Recommendation Report for Planning Permission for Works or Extension to a Dwelling

REF NO: FP/102/26/HH

LOCATION: 10 Downview Road
Felpham
PO22 8HG

PROPOSAL: Demolition of front porch and rear conservatory for the installation of a new front porch and rear extensions, including changes to fenestration and external materials

PROPOSED ELEVATIONS

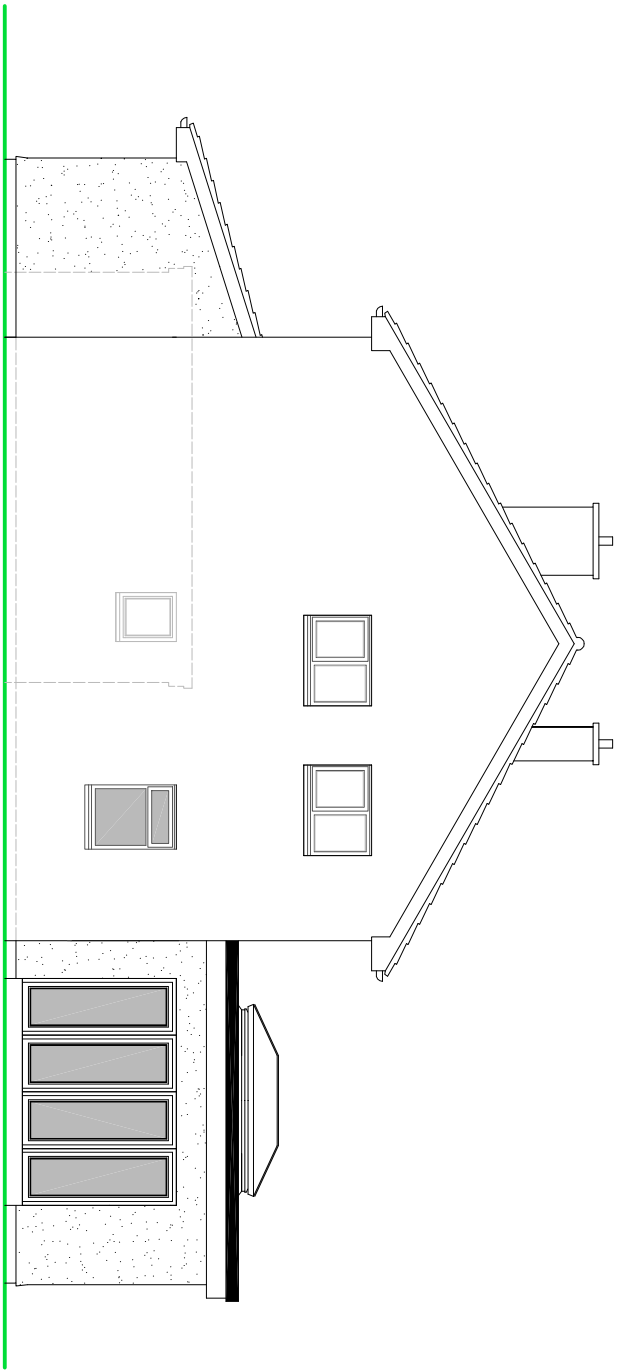
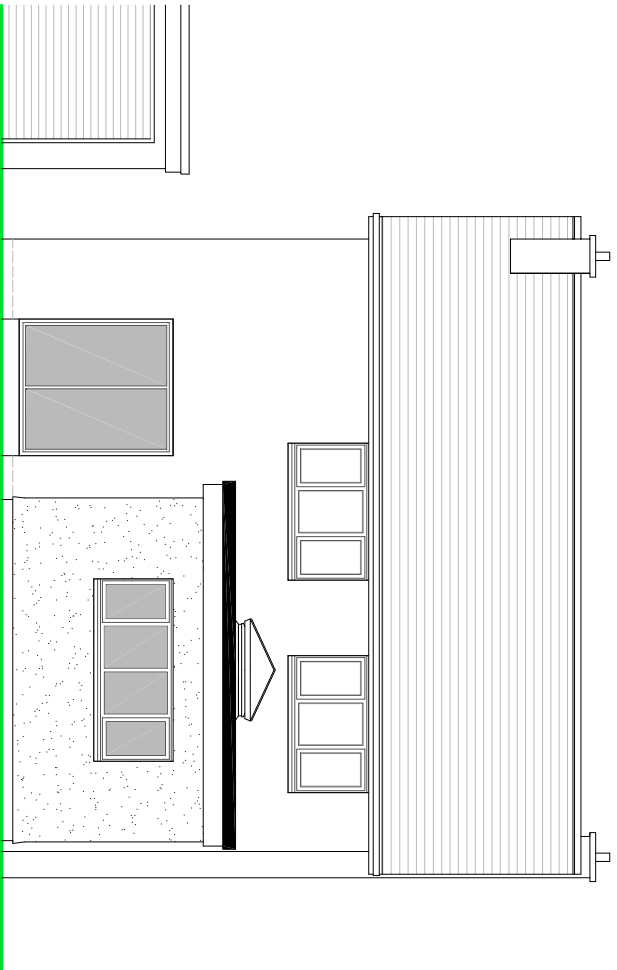
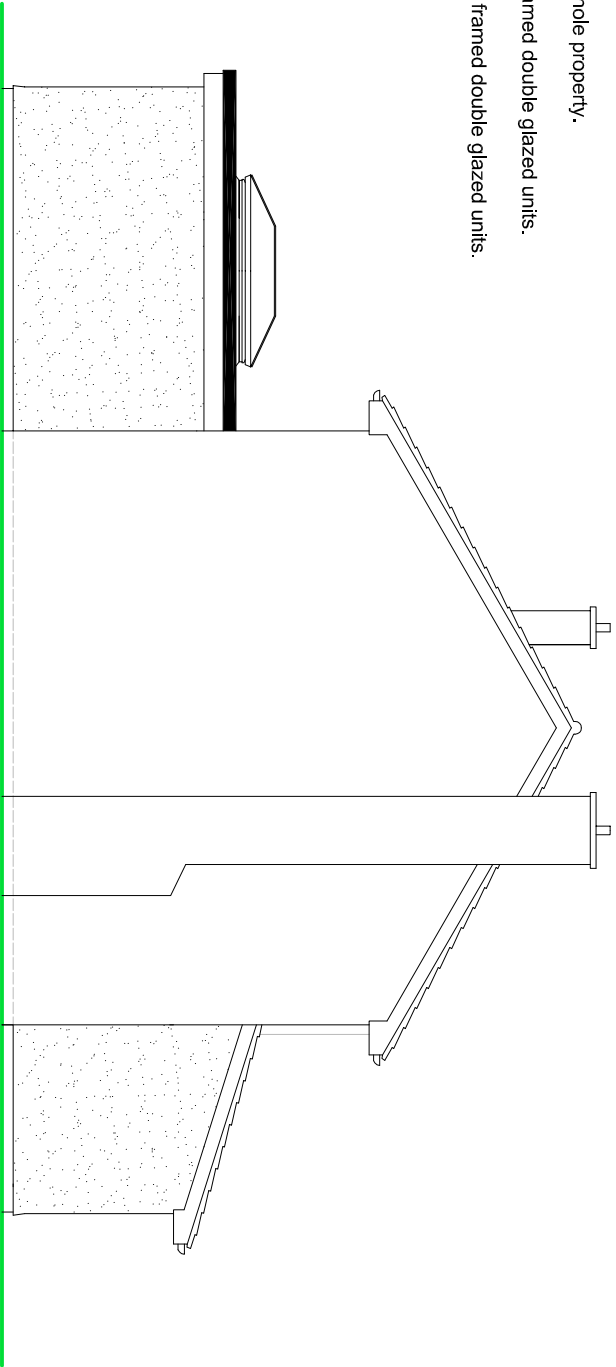
The proposed front porch would measure approximately 3.6m in width and 2.5m in depth. It would incorporate a pitched roof with an eaves height of approximately 2.3m and a maximum height of approximately 3.4m. The porch would feature a new aluminium entrance door, flanked by a full-height horizontal window. External materials would comprise painted render and roof tiles to match those of the host dwelling, ensuring visual integration with the property in accordance with the Arun Design Guide (ADG).

The proposed porch would exceed the guidance contained within the ADG, which states that front extensions should generally not project beyond 1.5m in depth. However, it would utilise matching materials and a sympathetic roof form, whilst replacing an existing porch structure. As such, the increase in footprint and departure from the ADG guidance would be acceptable and would not result in harm to the appearance of the host dwelling or the character of the surrounding area.

The proposed rear extension would measure approximately 4.5m in width and 4.5m in depth. It would have a flat roof form with a maximum height of approximately 3.6m, including the roof lantern. External materials would comprise a rendered finish to match the remainder of the dwelling, which is proposed to be fully rendered as part of the development. The extension would incorporate sliding doors within the south elevation, a window within the east elevation, and a roof lantern within the flat roof section.

Whilst the extension would exceed the ADG's recommended depth for rear projections of 3.3m, it would be located to the rear of the dwelling and would replace an existing conservatory. Furthermore, the extension would utilise matching materials and remain subservient in scale and appearance to the host property. Given its rearward location, it would not be readily visible from the public realm and would therefore not result in harm to the character or appearance of either the host dwelling or the surrounding area.

The proposal also includes alterations to the existing fenestration. The existing rear (east) window would be replaced with glazed patio doors, whilst the existing patio doors within the side (south) elevation would be replaced with a window. These alterations would visually match the existing fenestration and would utilise existing openings. As such, they would be acceptable.

PROPOSED GROUND FLOOR PLAN

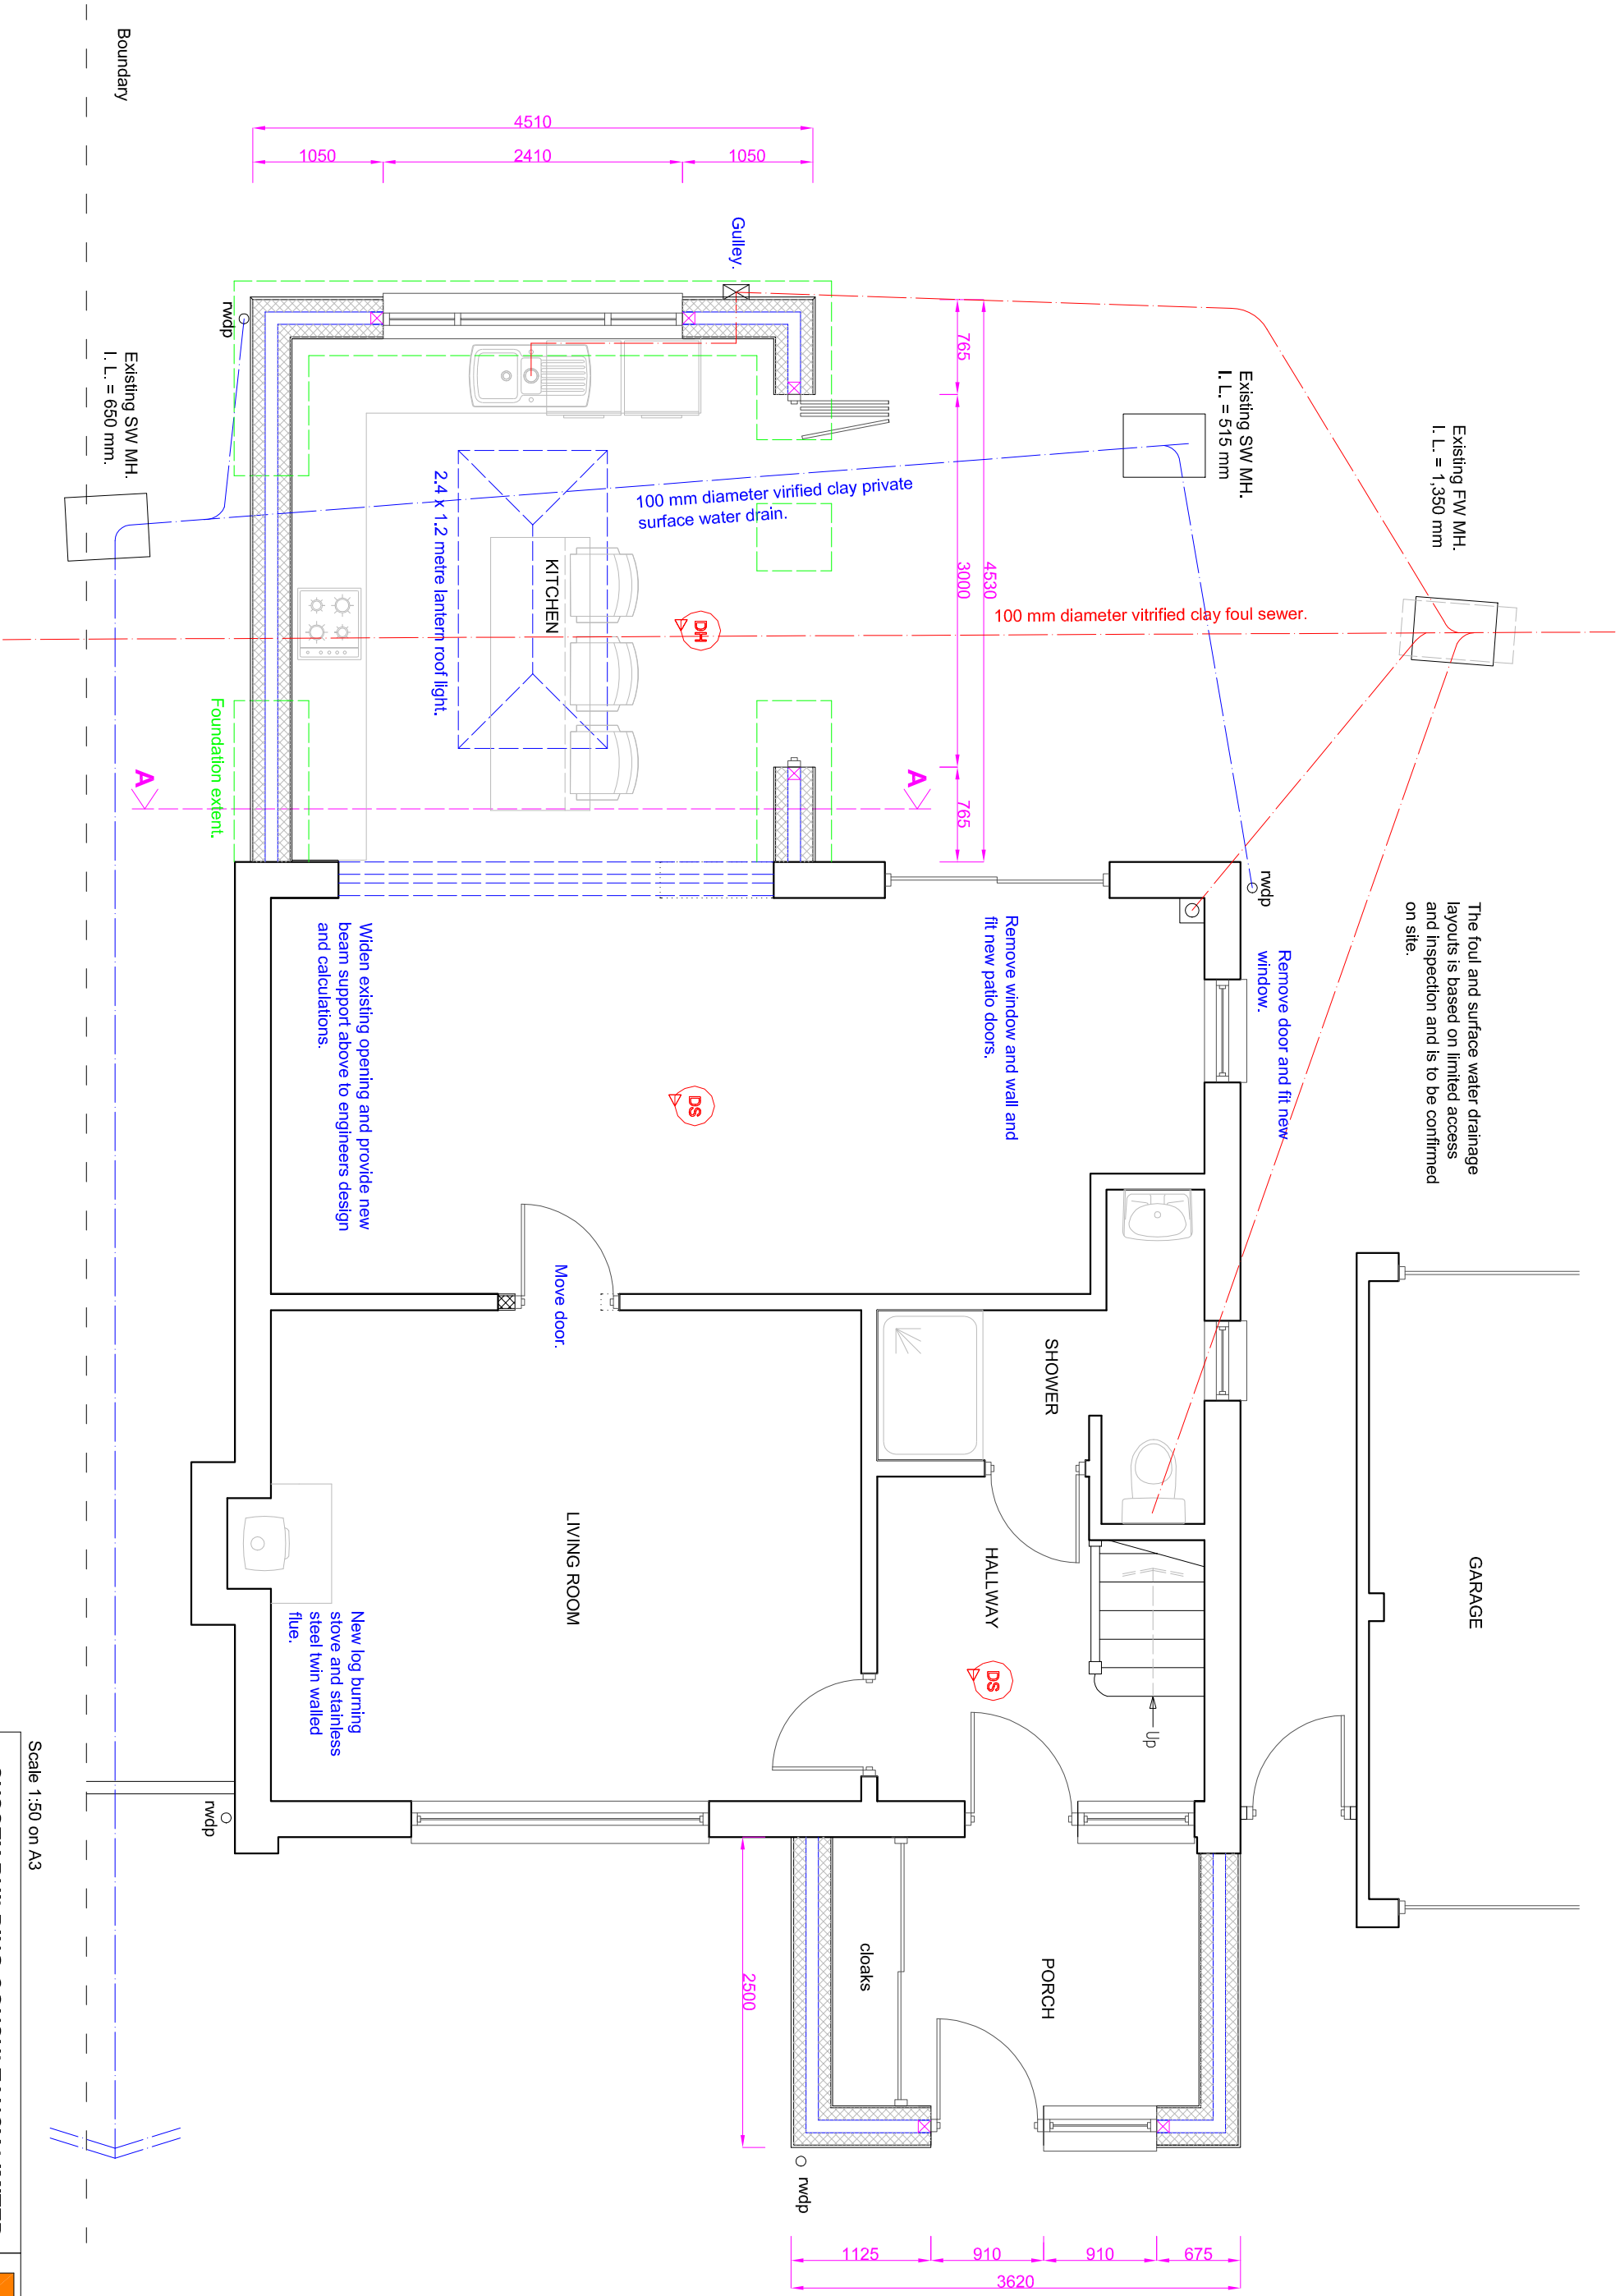
The proposed front porch would be set in approximately 5.8m from the northern side boundary and 7.3m from the southern side boundary. It would replace an existing porch and, given the generous separation distances, would not result in any overbearing or overshadowing impacts to neighbouring properties.

The rear extension would be set in approximately 1.3m from the northern side boundary and 11m from the southern side boundary. Due to its single-storey form, flat roof design and sufficient separation distances, the development would not result in any overbearing or overshadowing impacts to neighbouring occupiers. Furthermore it would replace an already established built form with a broadly

It is acknowledged that the proposal would not fully comply with the ADG in terms of garden amenity space, with a remaining depth of approximately 9m. However, sufficient amenity space of approximately 11m remains to the side of the rear extension, which is above the recommended 10.5m. The shortfall would be limited and the remaining amenity provision would be adequate for current or future occupiers.

PROPOSED ROOF PLAN

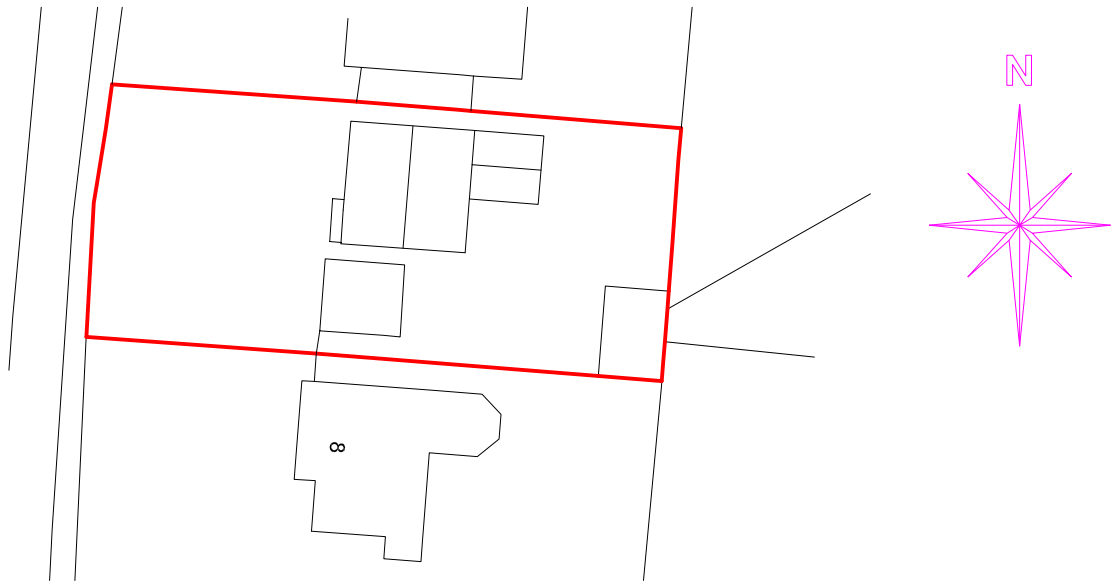
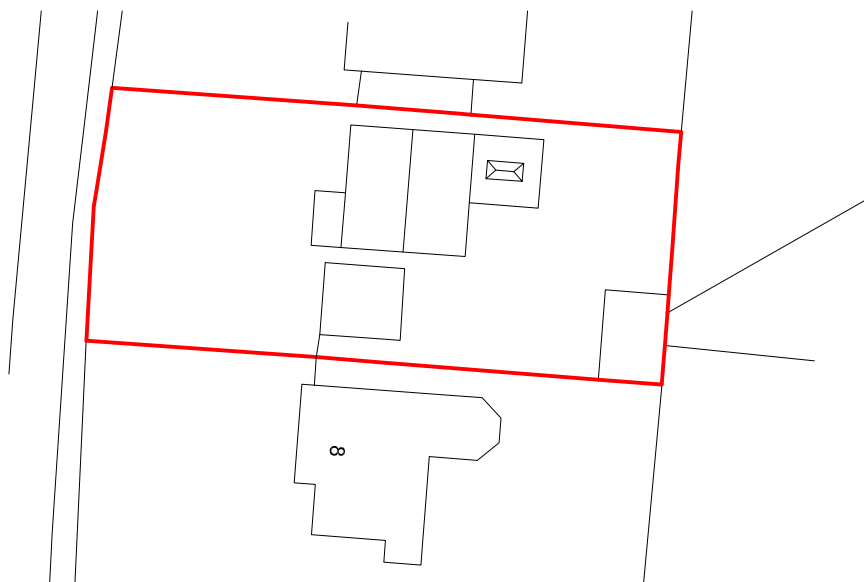
Openings within the rear extension would be overall reduced as existing conservatory is glazed on all elevations. The proposed windows would be contained within east and south elevations only, thereby improving the residential amenity of neighbouring occupiers when compared to the existing situation. Due to its position and angle, the proposed rooflight would not afford direct views towards neighbouring properties.

The proposed extension would also reduce the extent of glazing compared to the existing conservatory, which is glazed on all elevations. The proposed openings would be limited to the east and south elevations, thereby reducing opportunities for overlooking when compared to the existing situation. Due to its position and angle, the proposed roof lantern would not afford direct views towards neighbouring properties.
